EPC DPW Stormwater-PCM O&M Manual Comments.pdf Markup Summary

SDA-1

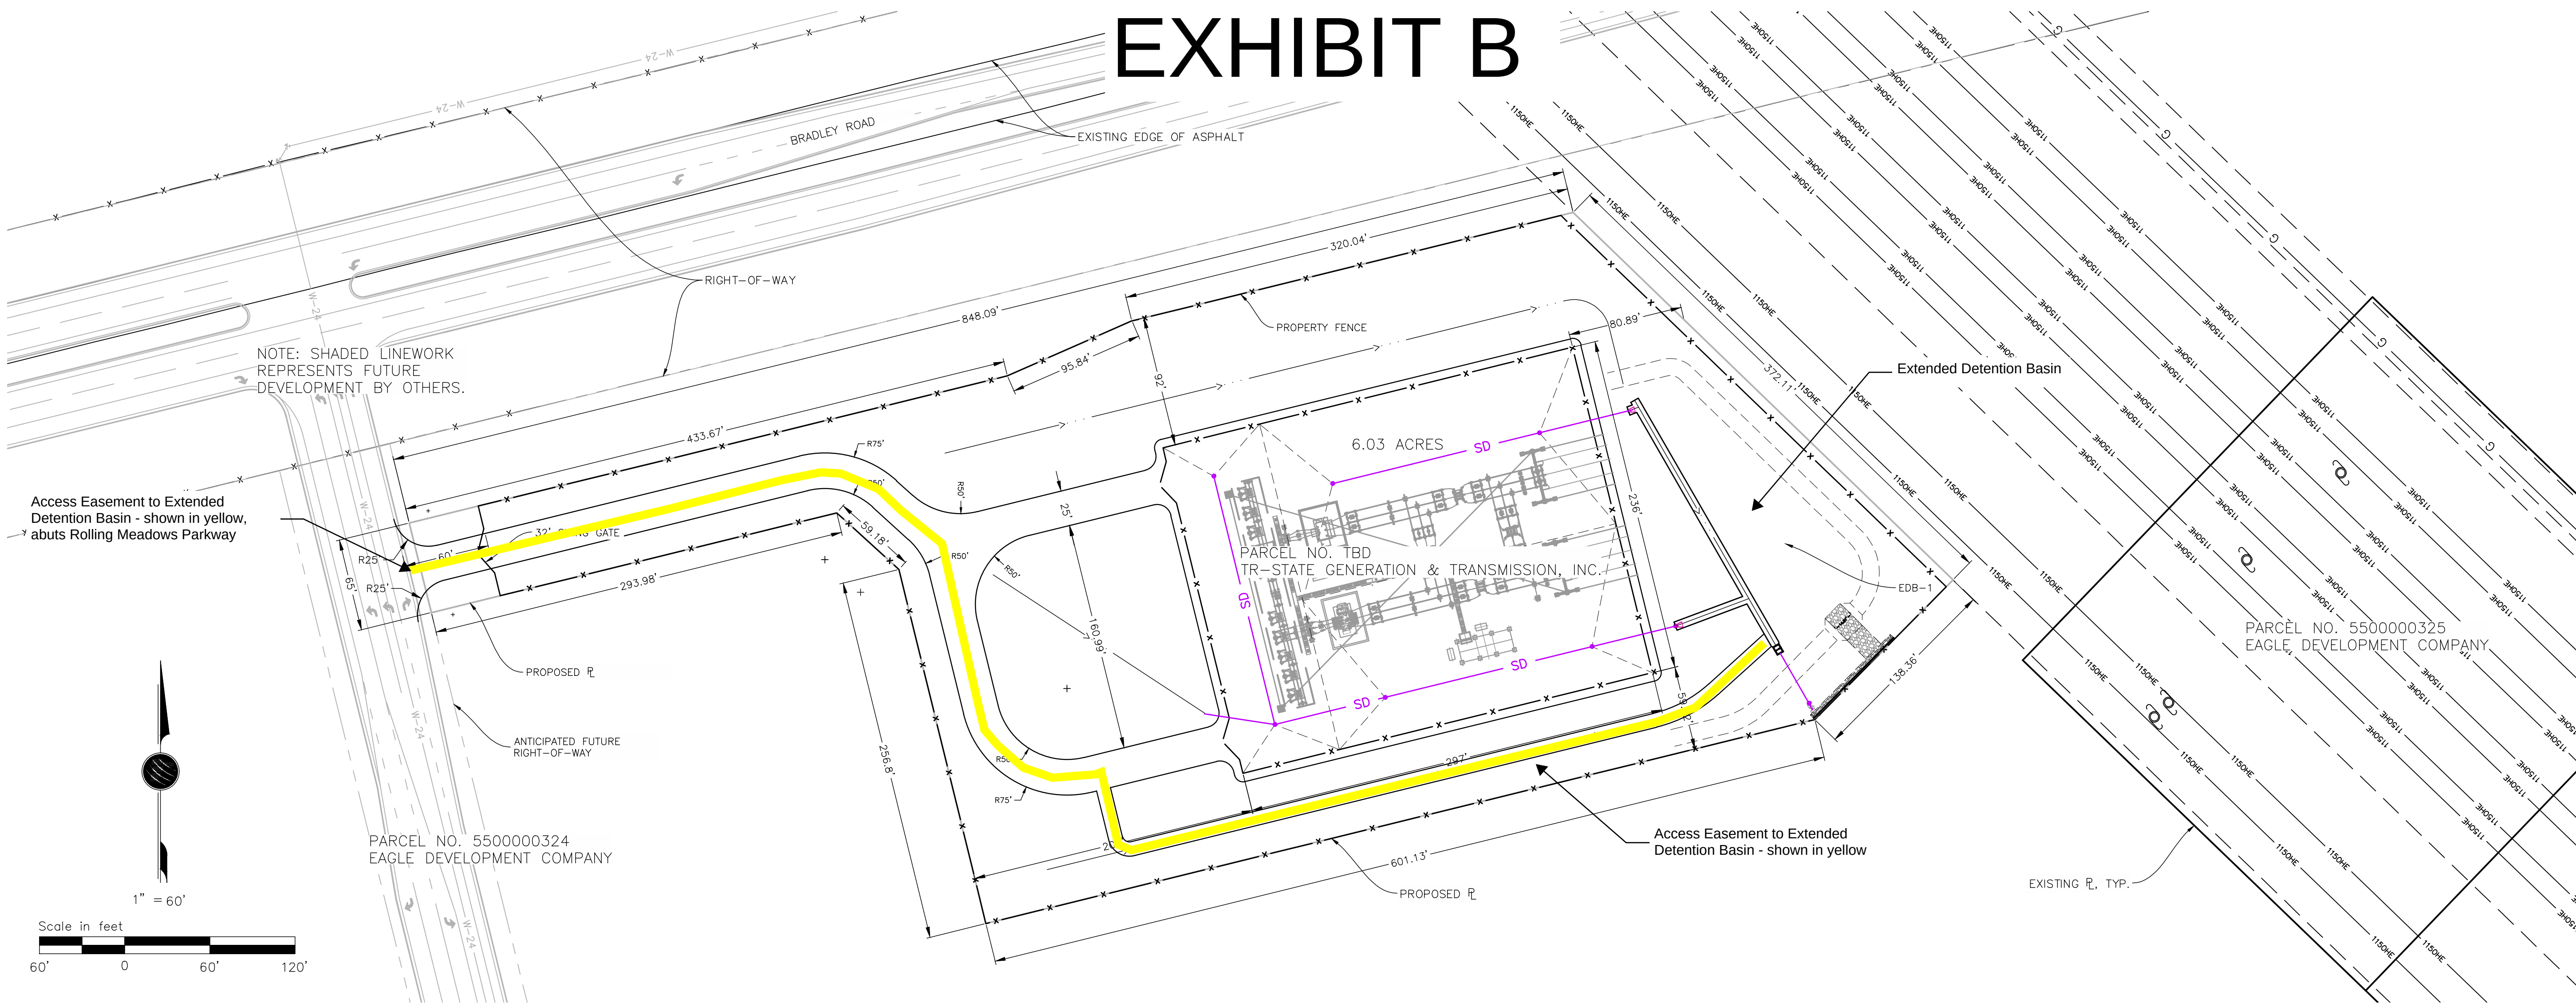
3 (1)		
floatables from blocking the outlet orifices. TING EXTENDED DETENTION BASINS (EDBs) cess and Easements nd maintenance personnel may utilize the attached s location(s) of the access points and maintenance eas ment. See comments on GEC Plan and adjust as needed. stormwater management practices locations id maintenance personnel may utilize the attached stor the location(s) of the EDB(s) within this development. Extended Detention Basin (EDB) Features number of features that are designed to serve a particu as of one feature dominates an outlet. For example	Subject: SW - Textbox	See comments on GEC Plan and adjust O&M as needed.
	Page Label: 3	
	Author: Mikayla Hartford	
	Date: 7/30/2026 10:26:07 AM	
	Status:	
	Color: ■	DMC RESPONSE: Additional language has been added referencing the 10' access road and confirming accessibility and traversability by owners maintenance staff.
	Layer:	
	Space:
